Re: Response to Review Comments
Flying Horse North Filing No. 3
El Paso, Colorado
Entech Job No. 231192
PCD No. SF2326

This letter is written in response to the Colorado Geological Survey (CGS) review comments dated March 3, 2024, concerning the on-site wastewater treatment systems OWTS evaluations and geologic constraints. The comments are addressed below. The report has also been revised to address the items discussed in this letter.

EL PASO COUNTY AND CGS COMMENTS AND ENTECH ENGINEERING, INC. RESPONSES

GEOLOGY/ENGINEERING MAP
 FLYING HORSE NORTH FILING NO. 3
 EL PASO COUNTY, COLORADO
 FLYING HORSE NORTH, LLC

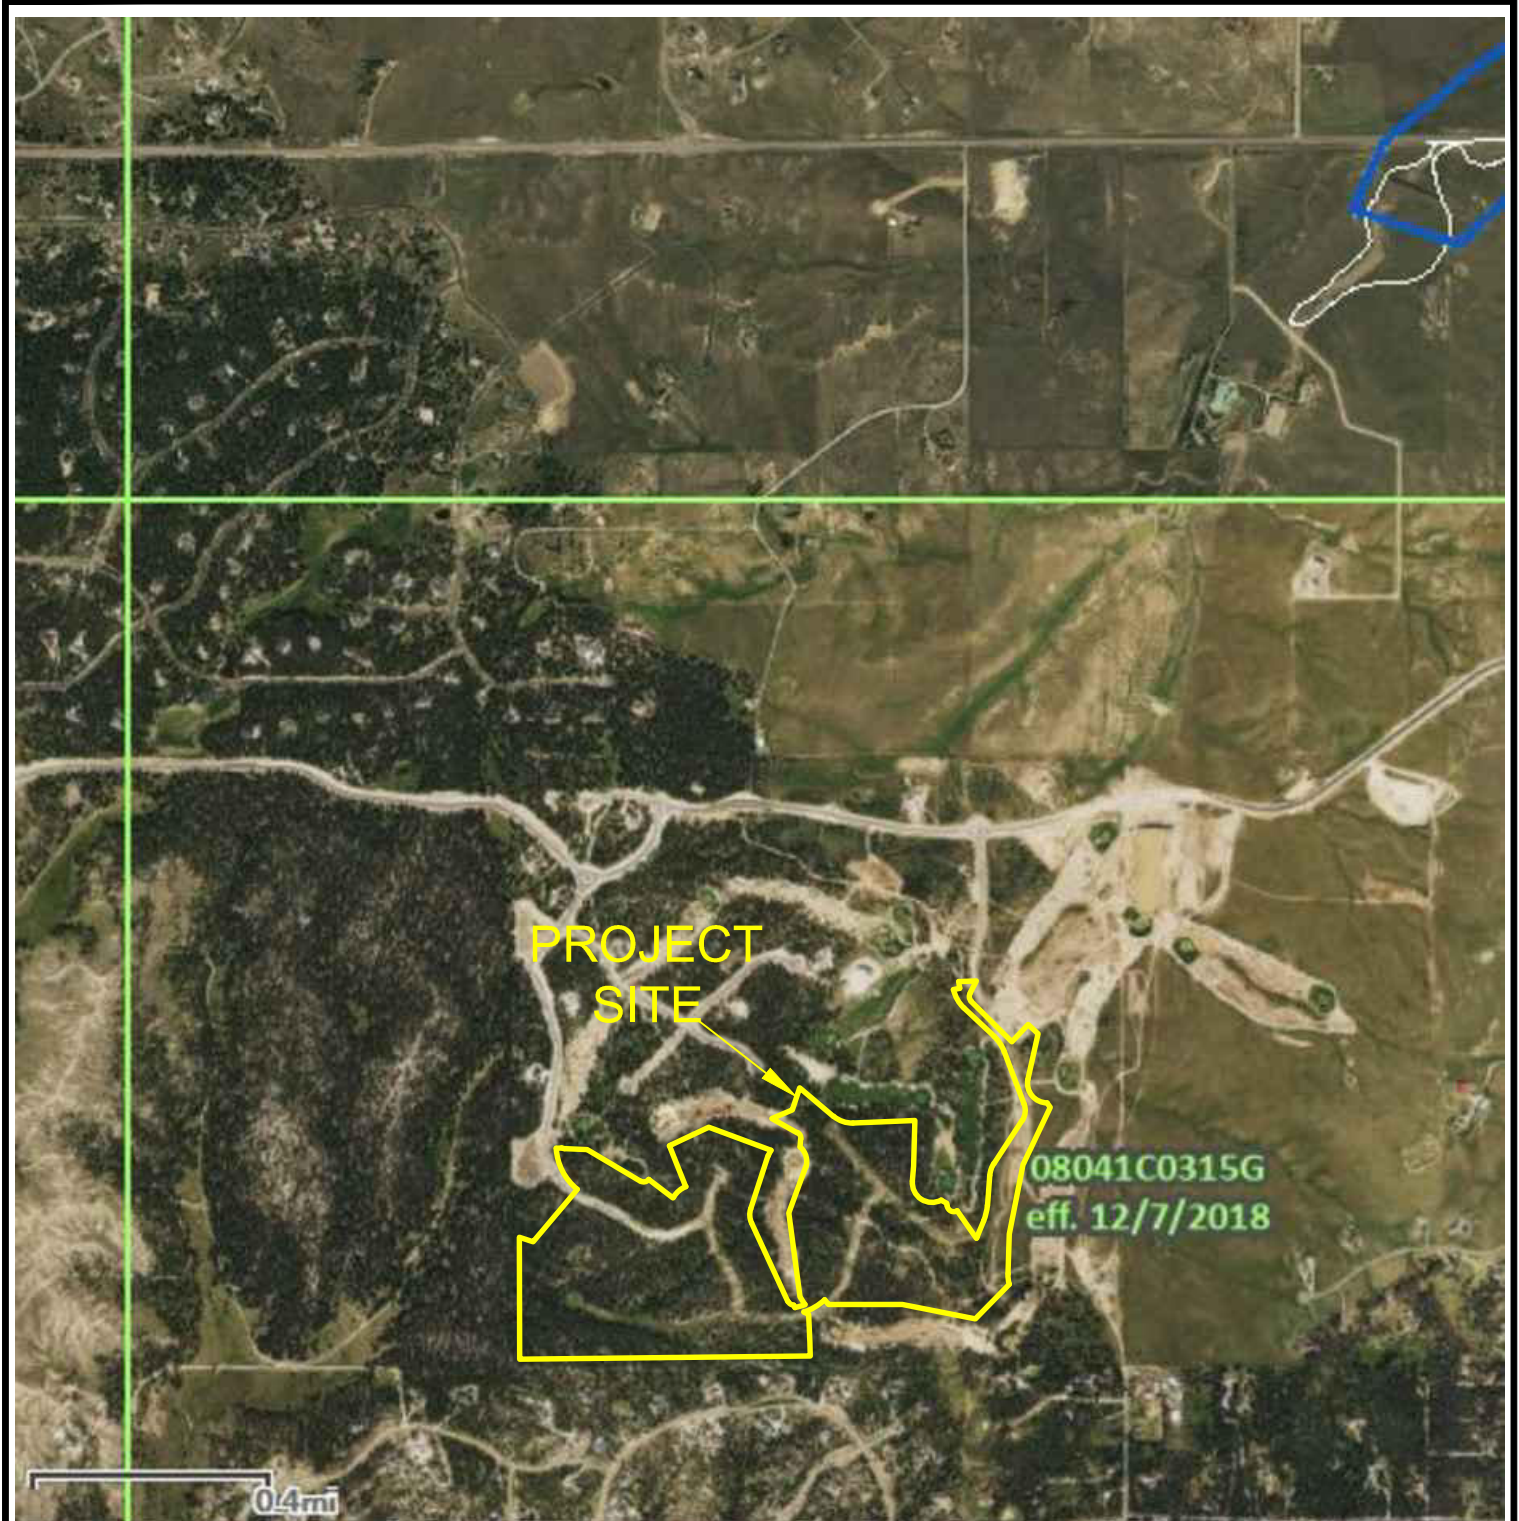
Comment: 4. “Erosional setbacks should be established near drainages and noted in the plans.

Entech Response: Entech agrees that setbacks should be provided on the plans. It is our understanding that the drainages align with the “psw” and “sw” areas mapped by Entech. Individual lot investigations should also discuss setbacks. The individual lot investigations should be based on site plans with house location and any site grading to be completed.

FLYING HORSE NORTH

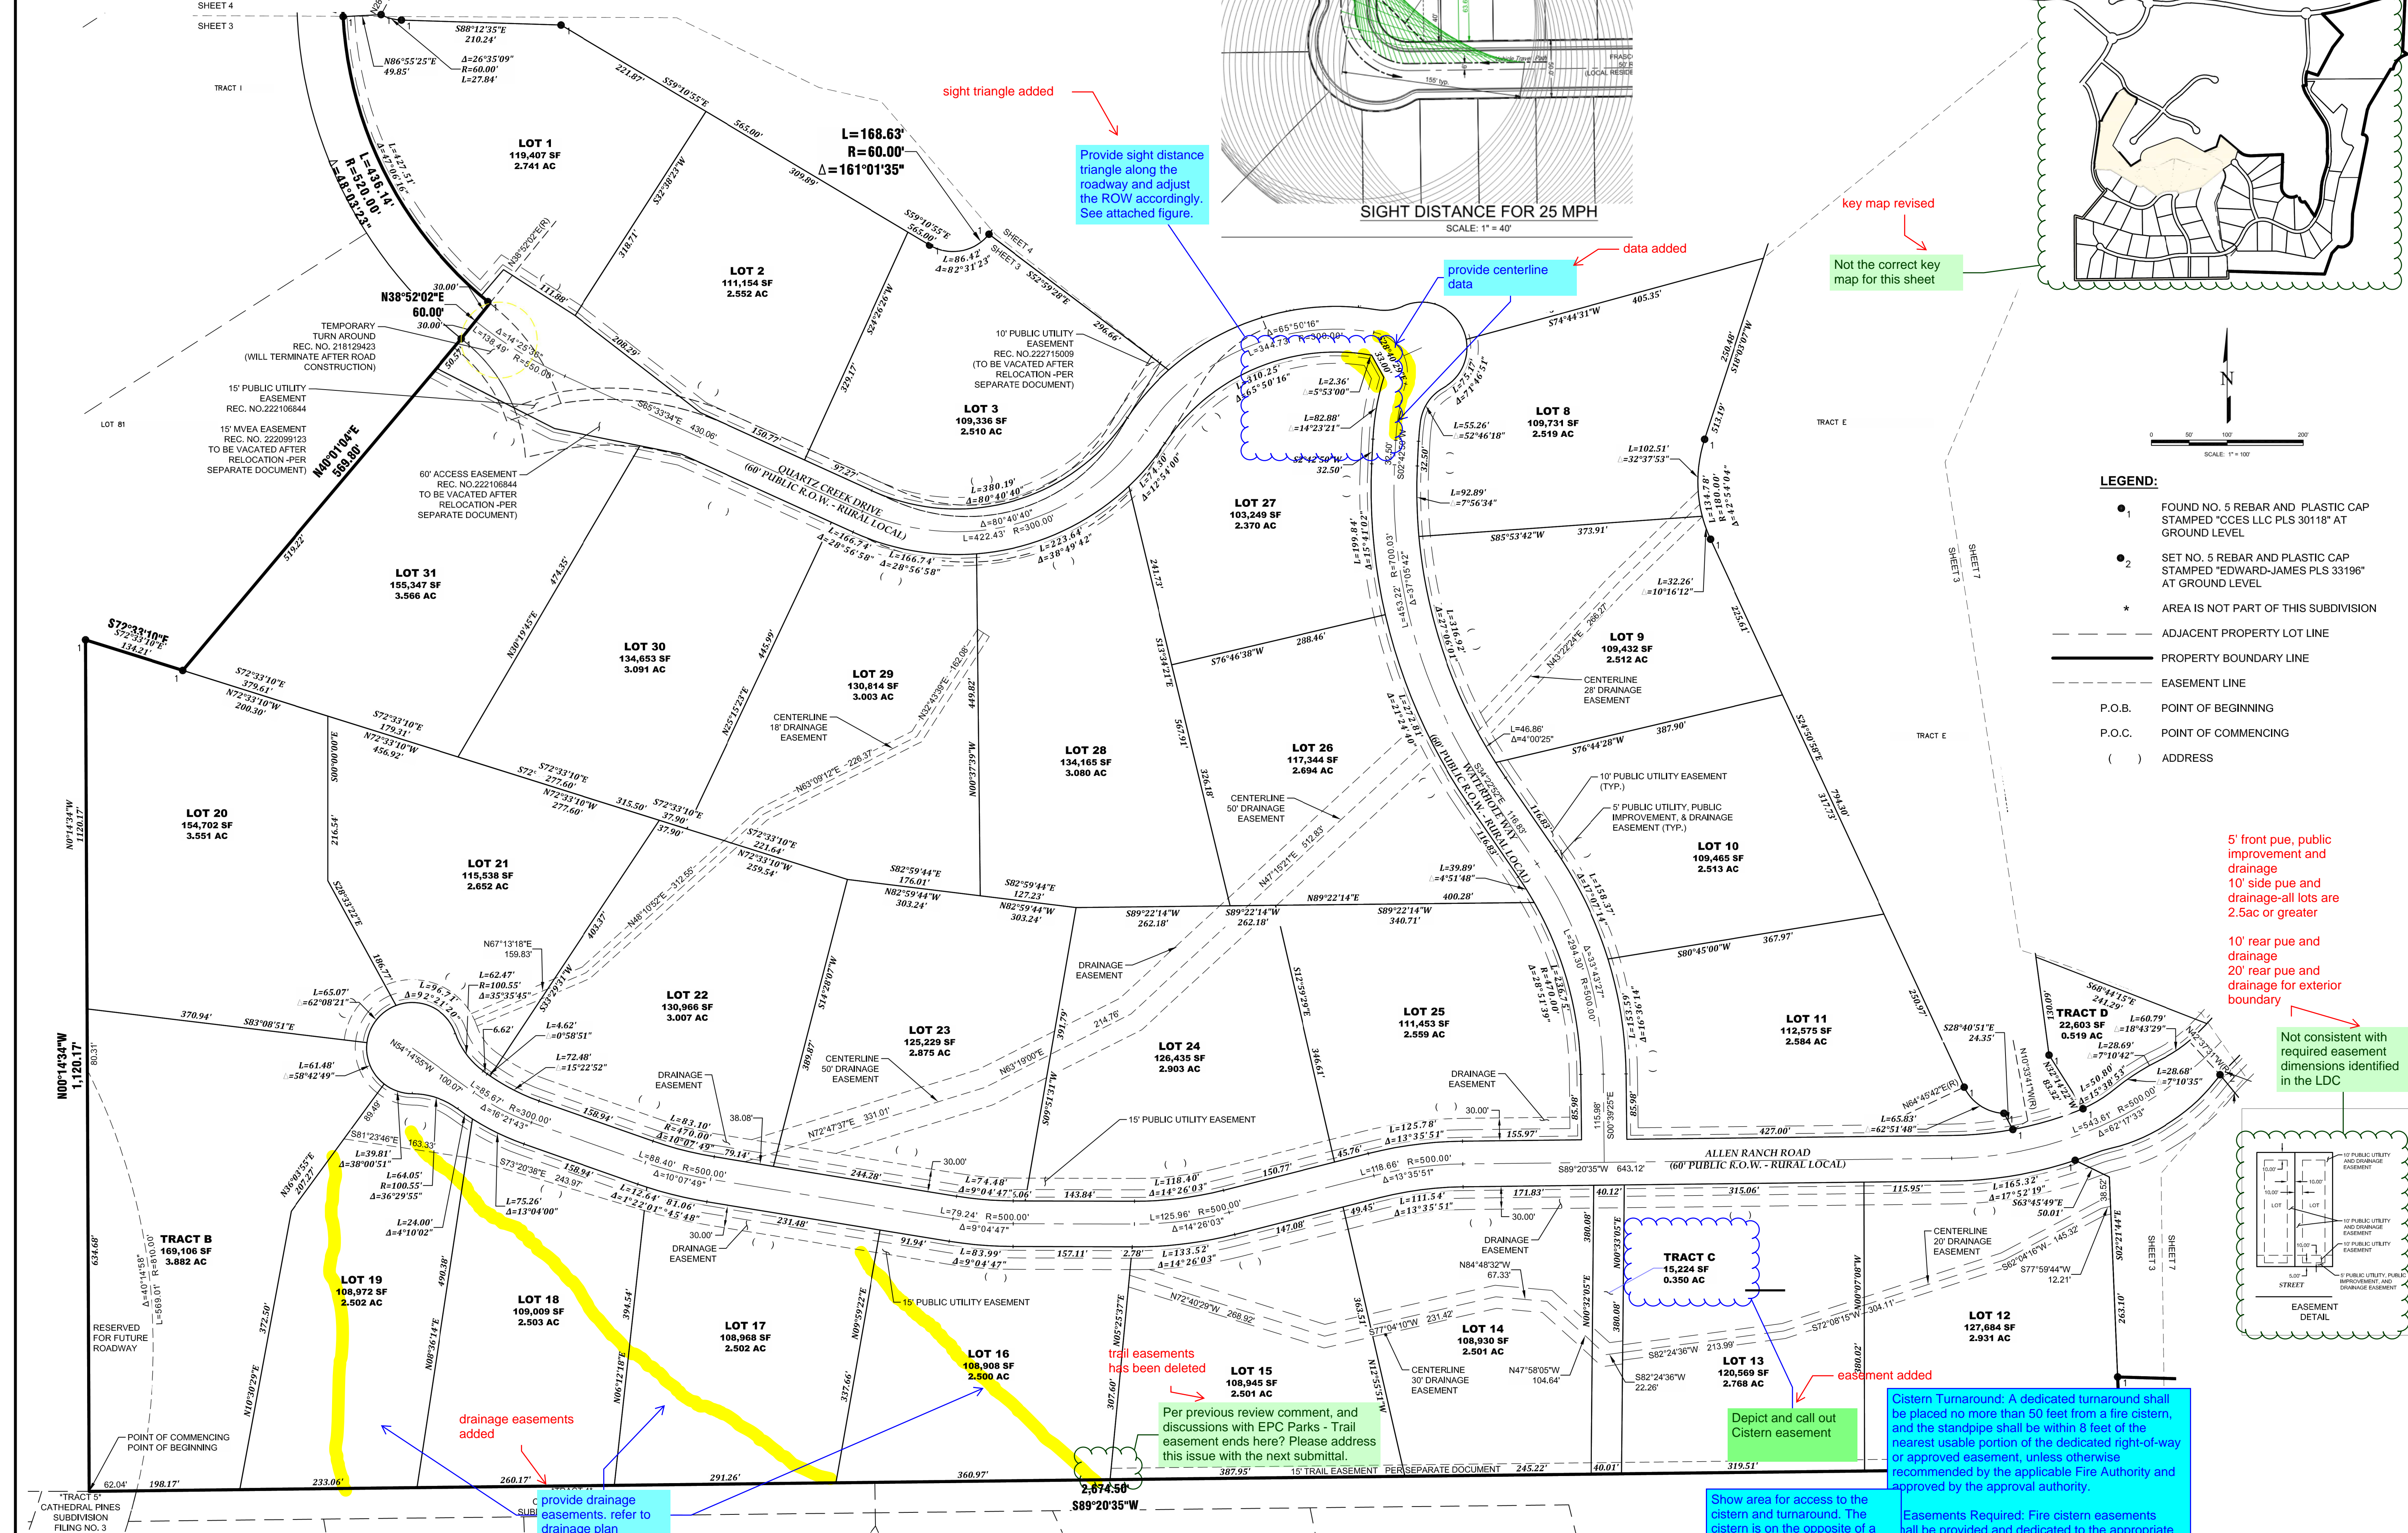
1. Note 27 on the final plat should be updated to reference Entech’s March 5, 2024 report and the geologic hazards listed. Lots located within areas of geologic hazards/constraints should be indicated on the plat. Downslope creep is a geologic constraint not currently listed on the final plat. – CGS

Entech Response: The following lots will be impacted by drainages that have been identified as Potentially Seasonal Shallow Groundwater and Seasonally Wet Areas: Lot Nos. 8, 9, 11 – 23, 28, 33 – 36, and 40 – 43. Areas within the lots are not suitable for construction or on-site wastewater treatment systems (OWTS).

The following lots will be impacted by Downslope Creep: Lot Nos. 4, 12, 13, 17, 18, 22, 28 – 31, 34 – 36, and 40 – 43. Lots affected by this constraint are acceptable as building sites, however, we would anticipate accelerated lateral and vertical movement of the near surface soils in the downslope direction. The design of foundations in these areas should account for the additional pressure on the uphill side of the structure due to the creep potential if structures are located in the downslope creep area. The lateral pressure distribution for sloping conditions in downslope creep area is presented in Figure 11 of the report. Additional recommendations are discussed in the report.
